## KITTITAS COUNTY COMMUNITY DEVELOPMENT SERVICES

March 18, 2009

### **RE: D. Knudson Short Plat (SP-08-00049)**

The Kittitas County Community Development Services Department has determined that the D. Knudson Short Plat (SP-08-00049) is a complete application and hereby grants *conditional preliminary approval* subject to the following conditions:

D KNUDSON SHORT PLAT
KITTITAS COUNTY SHORT PLAT NO. 08-XX
PORTION OF SECTION 31, TOWNSHIP 18N., RANGE 20E., W.M.
KITTITAS COUNTY, WASHINGTON

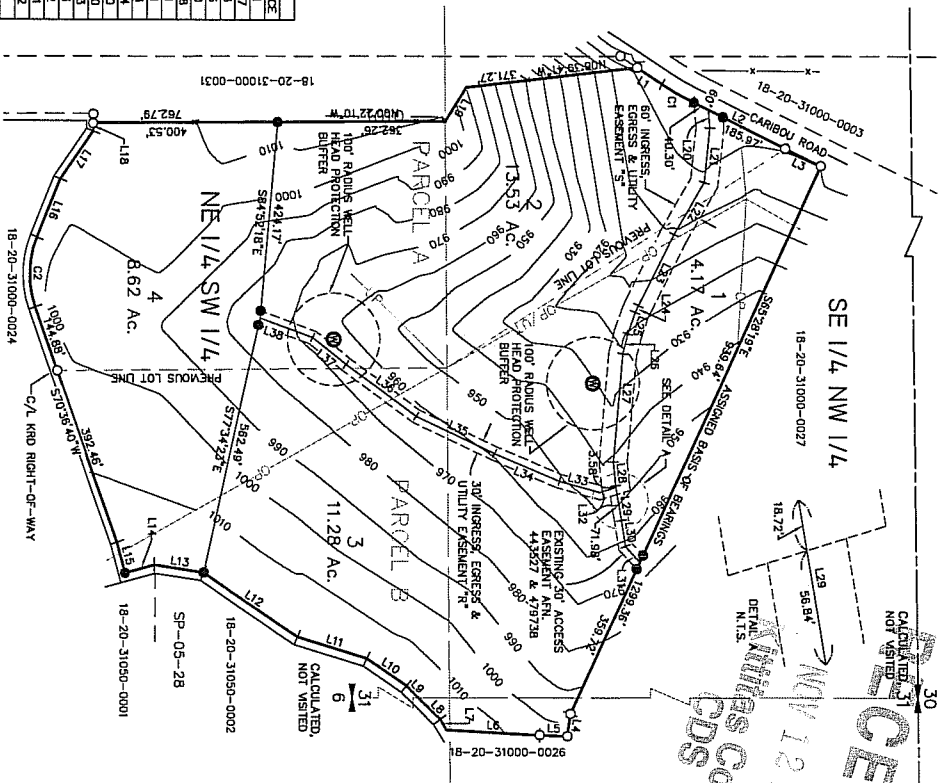
1. Both sheets of the final mylars shall reflect short plat number SP-08-00049 and an accurate legal description shall be shown on the face of the final plat.

2. Full year's taxes must be paid on all tax parcel numbers per requirement of the Kittitas County Treasurer's Office.
3. The following plat notes shall be recorded on the final mylar drawings:

- All development must comply with International Fire Code.
  - The subject property is within or near designated natural resource land of long-term commercial significance on which a variety of commercial activities may occur that are not compatible with residential development for certain periods of limited duration. Commercial natural resource activities performed in accordance with county, state and federal laws are not subject to legal action as public nuisances. (RCW 7.48.305)

- The approval of this division of land includes no guarantee that there is a legal right to withdraw groundwater within the land division. The approval of this division of land provides no guarantee that use of water under the ground water exemption (RCW 90.44.050) for this plat or any portion thereof will not be subject to curtailment by the Department of Ecology or a court of law.

- Kittitas County will not accept private roads for maintenance as public streets or roads until such streets or roads are brought into conformance with current County Road Standards. This requirement will include the hard surface paving of any street or road surfaced originally with gravel.

10. The addresses shall be clearly visible from both directions at the County Road for all properties.
11. The Fire Department access road shall be capable of supporting 75,000 lbs in all weather, be 20' wide, provide 13'6" vertical clearance and provide for adequate turn-around for fire department apparatus.
